From: Stuart Magowan [REDACTED]
Sent: 25 September 2020 11:36
To: Anita Gardner <Anita.Gardner@arun.gov.uk>; Paul Cann <Paul.Cann@arun.gov.uk>
[REDACTED]

Subject: RE: F/21/20/DOC Wicks Farm

The following link will allow a download of the drawings as noted on the attached drawing issue register together with the updated Reservoir Calculations and Management and Maintenance Plan. For ease of reference I have noted our responses in green below to the latest comments.

CLIENT DPS Limited	
PROJECT Wicks Farm Polytunnel Ford	
TITLE Sections	
DRAWN P Reynolds	DATE Aug 2020
ENGINEER S Burgess	CHECKED SB
SCALE As shown @ A1	
PROJECT NO. 23210	
REV

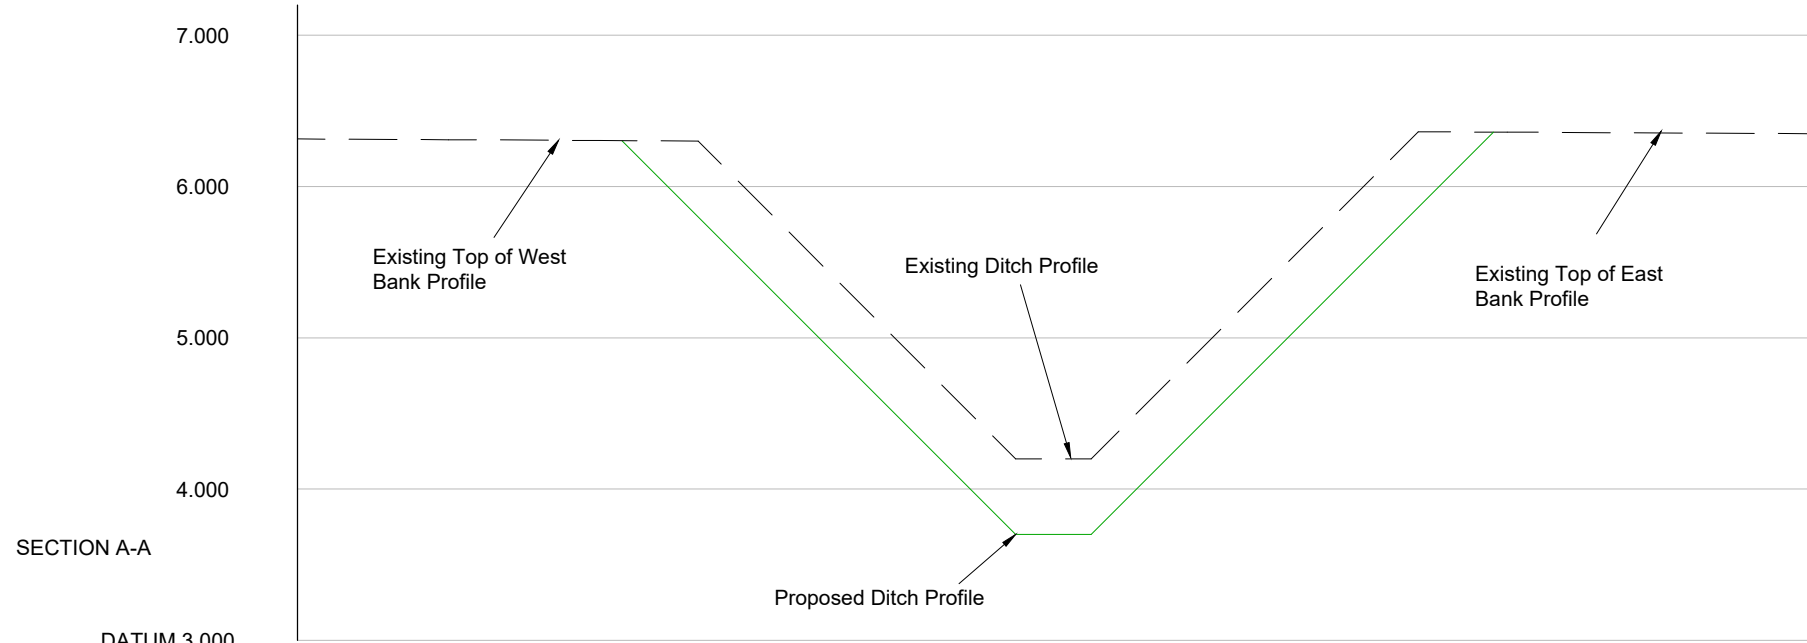
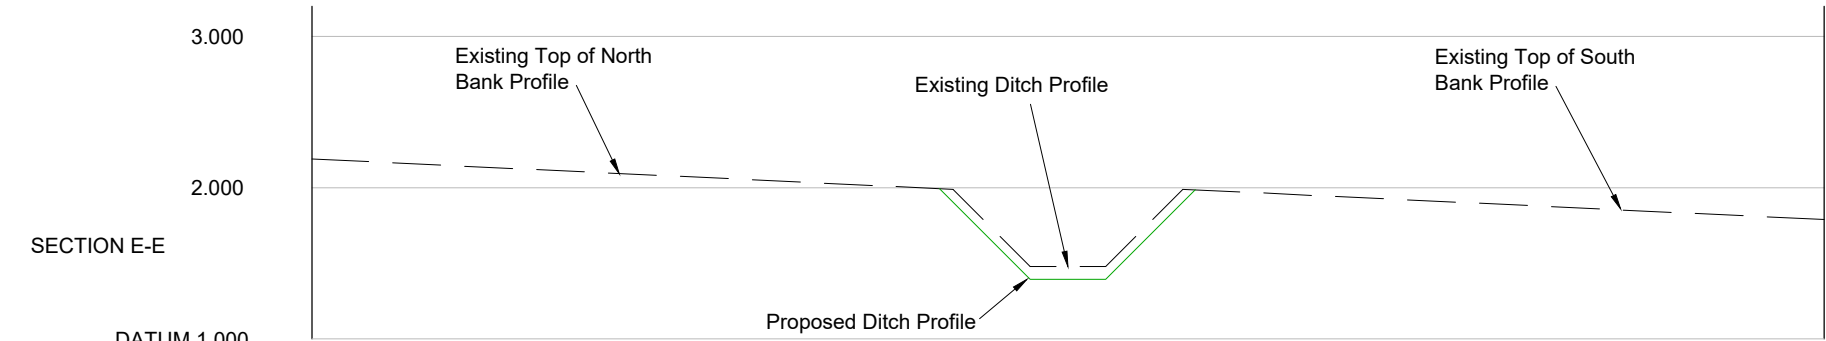
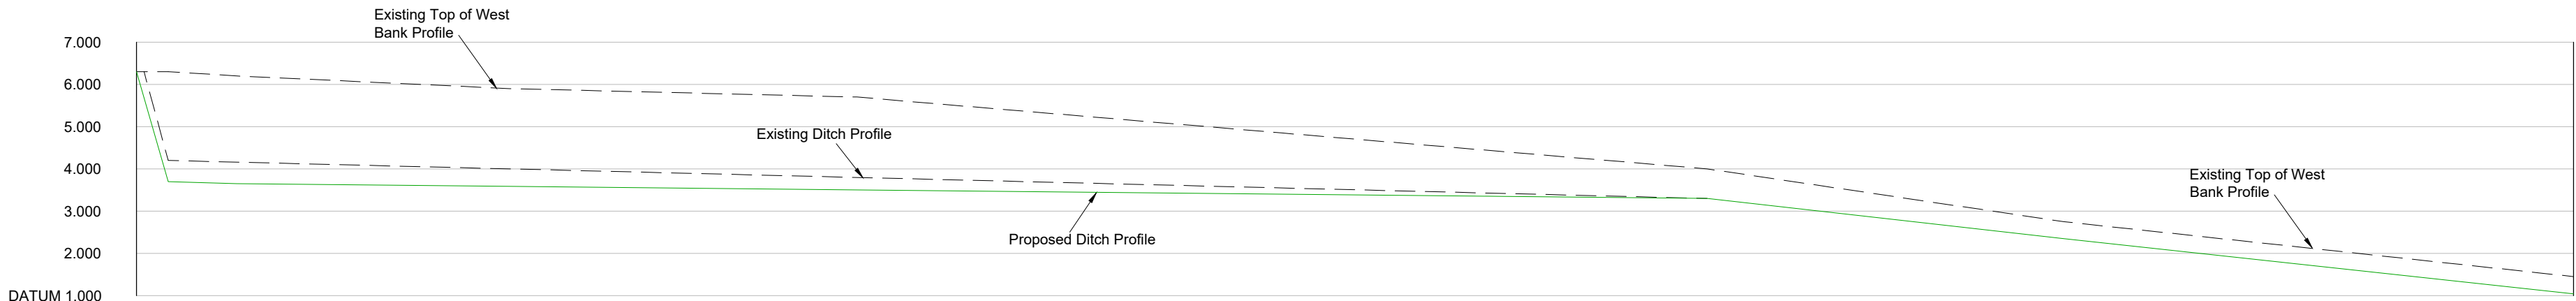
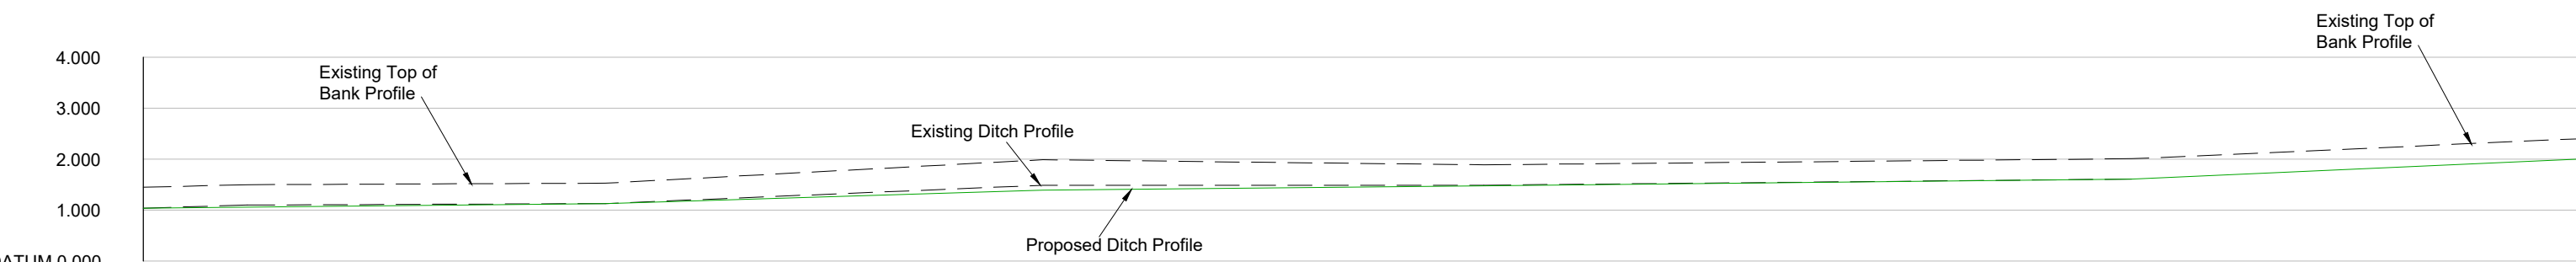
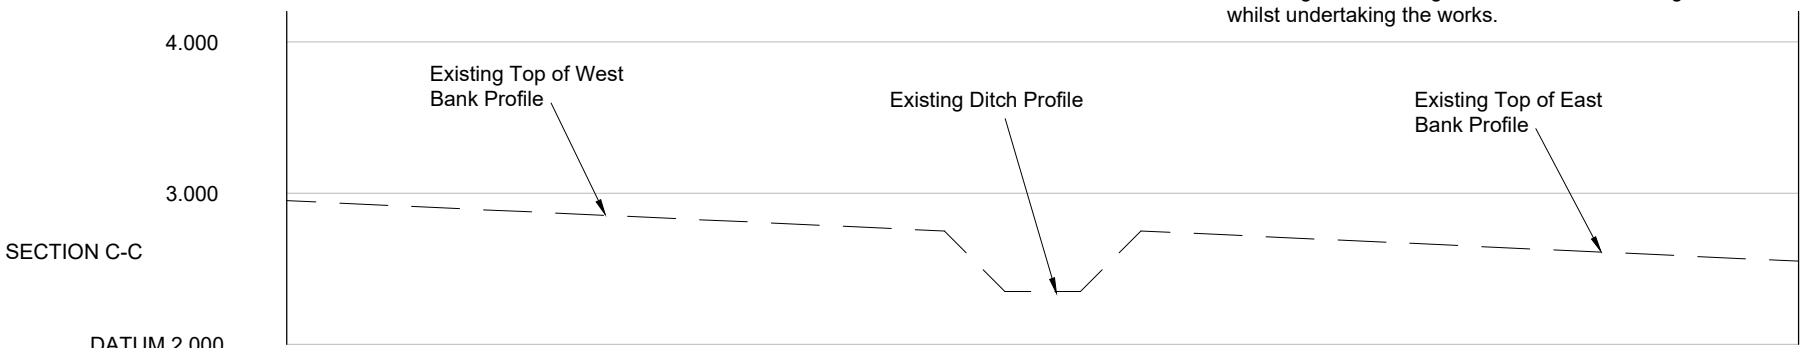
1. The northern boundary ditch in vicinity of the proposed reservoir is currently located on the other side of the network rail fence and not within the redline boundary. As previously suggested a ditch

will be required within the red line boundary and running parallel to the network rail ditch. Please adjust drawings and provide a typical profile cross section. Land drainage consent is also required for the new ditch and headwall outlet. There is an existing ditch on site at the northern boundary and a further ditch the other side of the Network Rail fence, the existing ditch is noted to be cleared of debris, vegetation and silt and regraded where required. This is indicated on drawings 21E, 22E and 24E. The comments on Land Drainage Consent are noted but are not a reason to refuse discharge of condition as they are covered by separate legislation. My last visit to site indicated that there was no obvious ditch in vicinity of the reservoir, apart from the one on the other side of the Network Rail fence, however, provided the ditch is installed as per the drawings then this is not an issue. On the cross sections ie. D-D and E-E, clearly indicate the ditch base width and the gradient of the side slopes. Land drainage consent is an integral part of the outstanding conditions ie. no.8, and in this instance, I am prepared to allow the consent to be just made for the headwall structure/discharge -- please therefore submit as necessary. Noted. The ditch base and bank gradients have been added to all sections A-A to E-E. See Drawing 70.

11. **Provide longitudinal section showing existing and proposed bed levels.** This is an existing ditch, we have provided the existing levels on the submitted drawings, long section is included in the above link on drawing 70. Ok. Noted.

R10CA HEADWALL
 + 400MM TOE
 + HINGED CRANKED GRATING

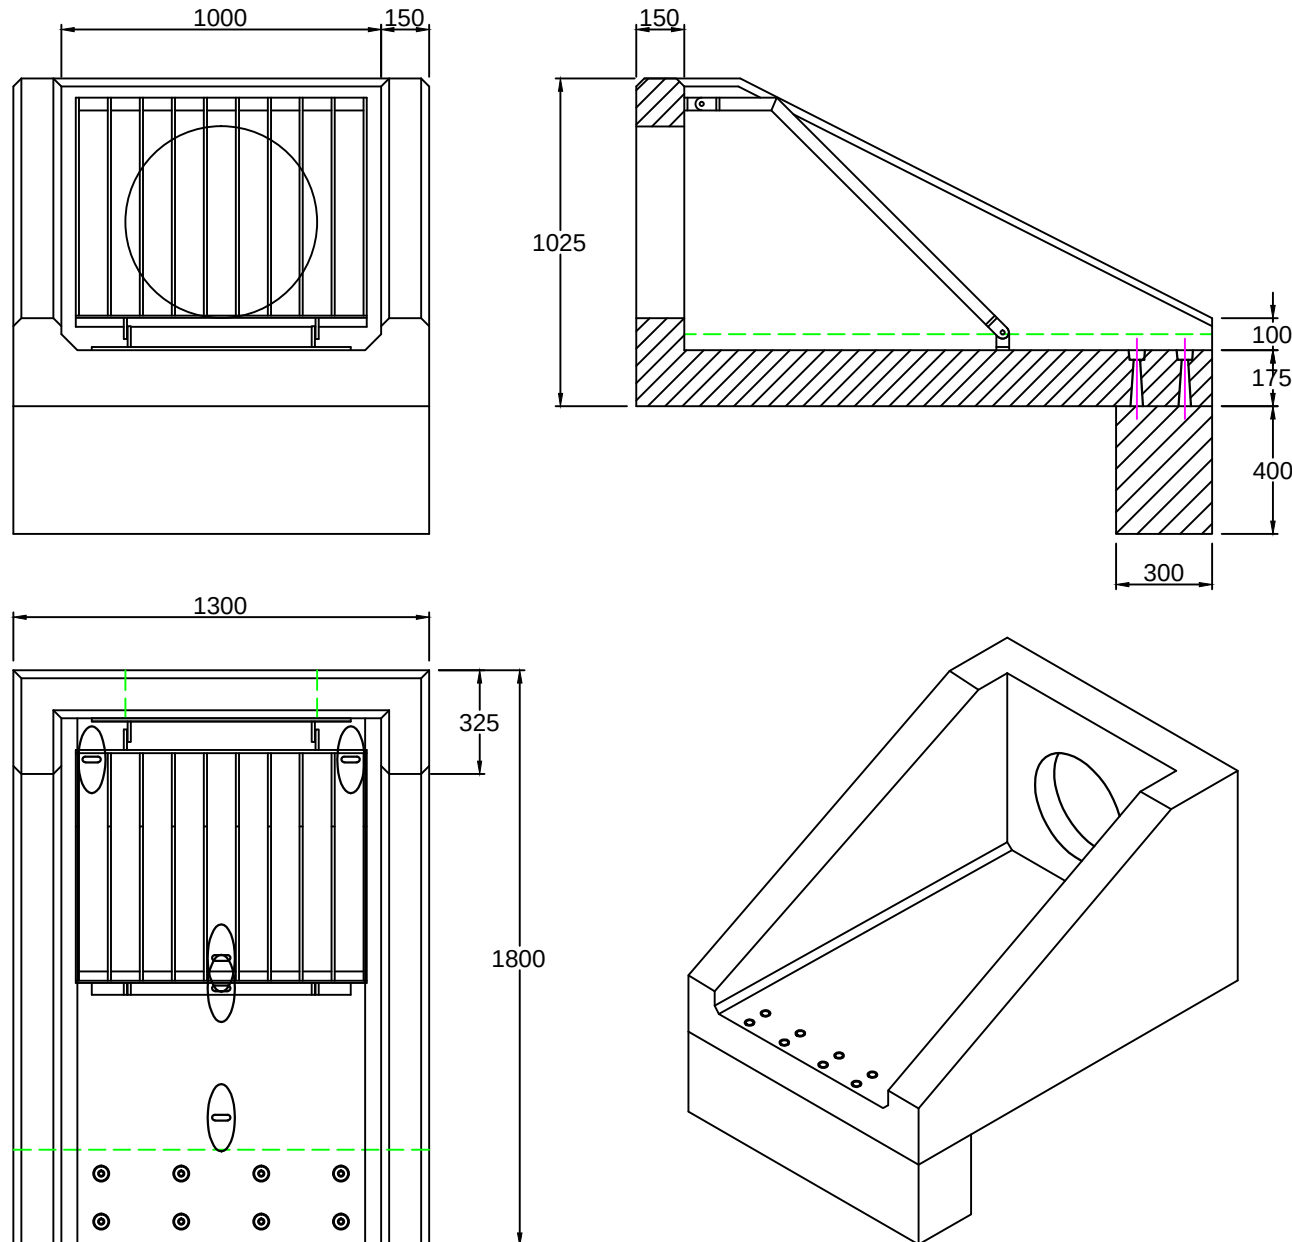
5. **Overflow pipe from reservoir provide headwall with cranked grille with bar spacings to suit 150mm diameter pipe. Include construction detail.** Detail of Althon Headwall R10CA with cranked grill and installation instructions provided on 13 July 2020 and are included in the link above on drawing 53. Ok. Noted.
